Submission Form

Epping to Thornleigh Third Track Proposal. Application number SSI 5132.

Name(s): PHIL & SUSAN MOORE

Figure S.6 Cross-section and elevation - New Cheltenham Station concourse building (see also S.5 for artist's impression)

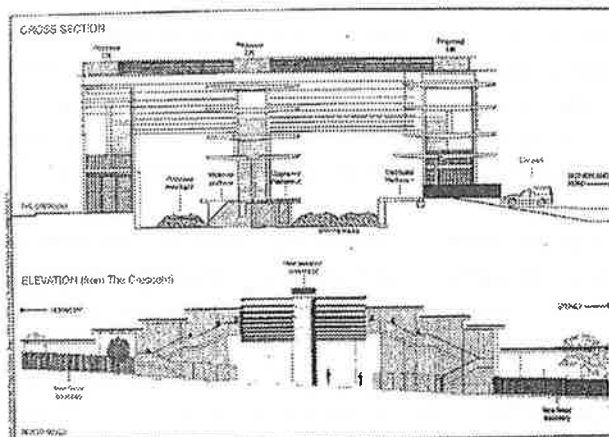
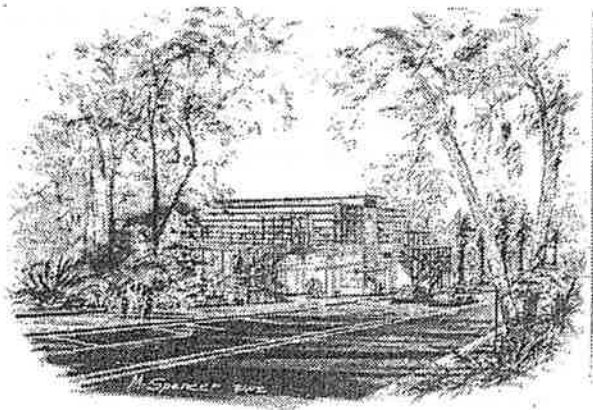
- The proposed redevelopment of Cheltenham Station shows no regard for the HCA. The visual impact of the proposed 13m high glass and steel concourse is totally unacceptable in this HCA.
